Subject: Objection to Planning Applications 2025/61/92713/E and 2025/44/92737E - -Moor Lane, Gomersal

Objection to Planning Applications 2025/61/92713/E and 2025/44/92737E

Bin Collection Points and Bin Drag Distances

Client: PPJ Developments
Project: 2539 - Moor Lane - Residential
Title: GA Plans & Elevations HT03

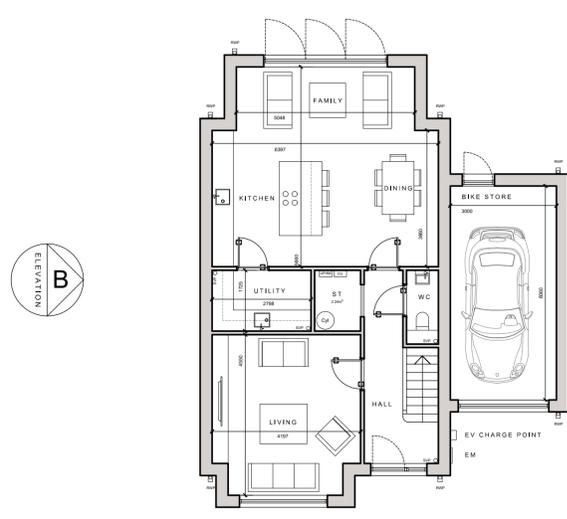
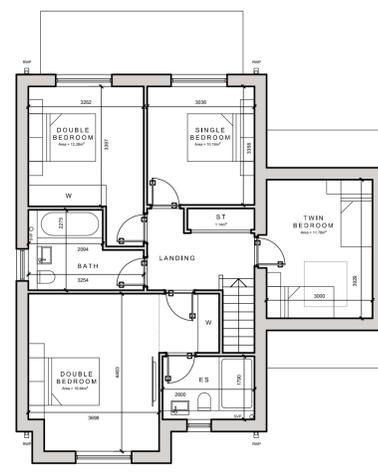
Plot 10 (HT05)	Width 7310	Depth 11389	Garage Width 3000	Pathways width	????					
Plot 9 (HT03)	Width 6397	Depth 11935	Garage Width 3000	'''	'''	'''				
Plot 8 (HT03)	'''	'''	'''	'''	'''	'''	'''	'''	'''	'''
Plot 7 (HT03)	'''	'''	'''	'''	'''	'''	'''	'''	'''	'''

Plot 9 - minimum 34 metres (excluding pathway widths)

Plot 8 - minimum 27.5 metres (excluding pathways widths)

Plot 7 - minimum 18 metres (excluding pathways widths)

Client PPJ Developments
Project 2539 - Moor Lane - Residential
Title GA Plans & Elevations HT05

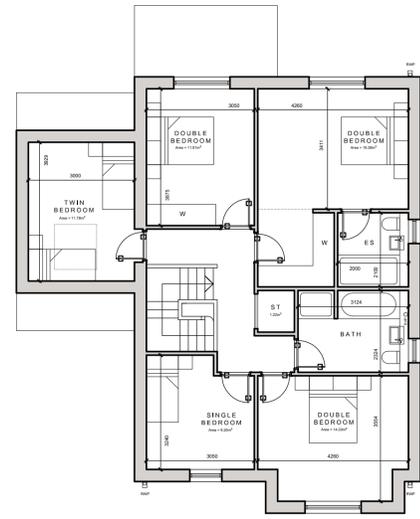
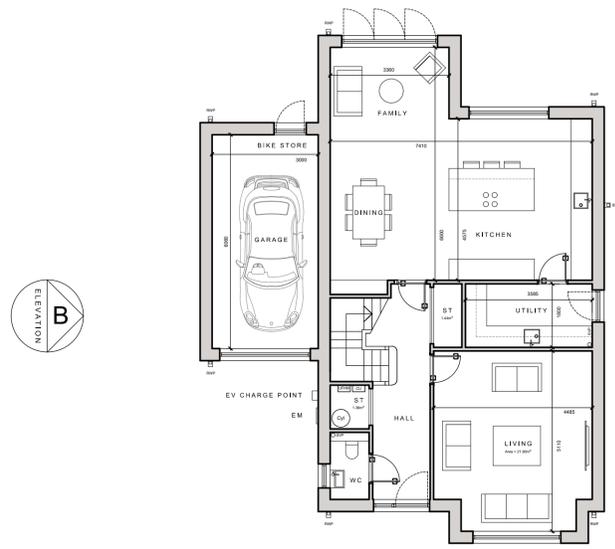
Plot 10 - minimum 57 metres (excluding pathway widths)

2539 - D - 20 - 002

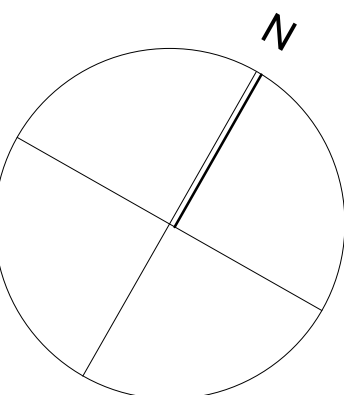
Plot 7, 8 9 and 10 are located down a private drive which will mean residents will have to drag their bins to the bin collection point, located at the end of the private drive.

The drags distance for plot 8, 9 and 10 all exceed this maximum 25metre.

Based on the above estimated plot sizes, the bin drag distance shown on this application for:

Therefore only Plot 7's drag distance is below the maximum allowable drag distance of 25 metres and Plots 8,9 &10 all exceed the maximum allowable drag distance.
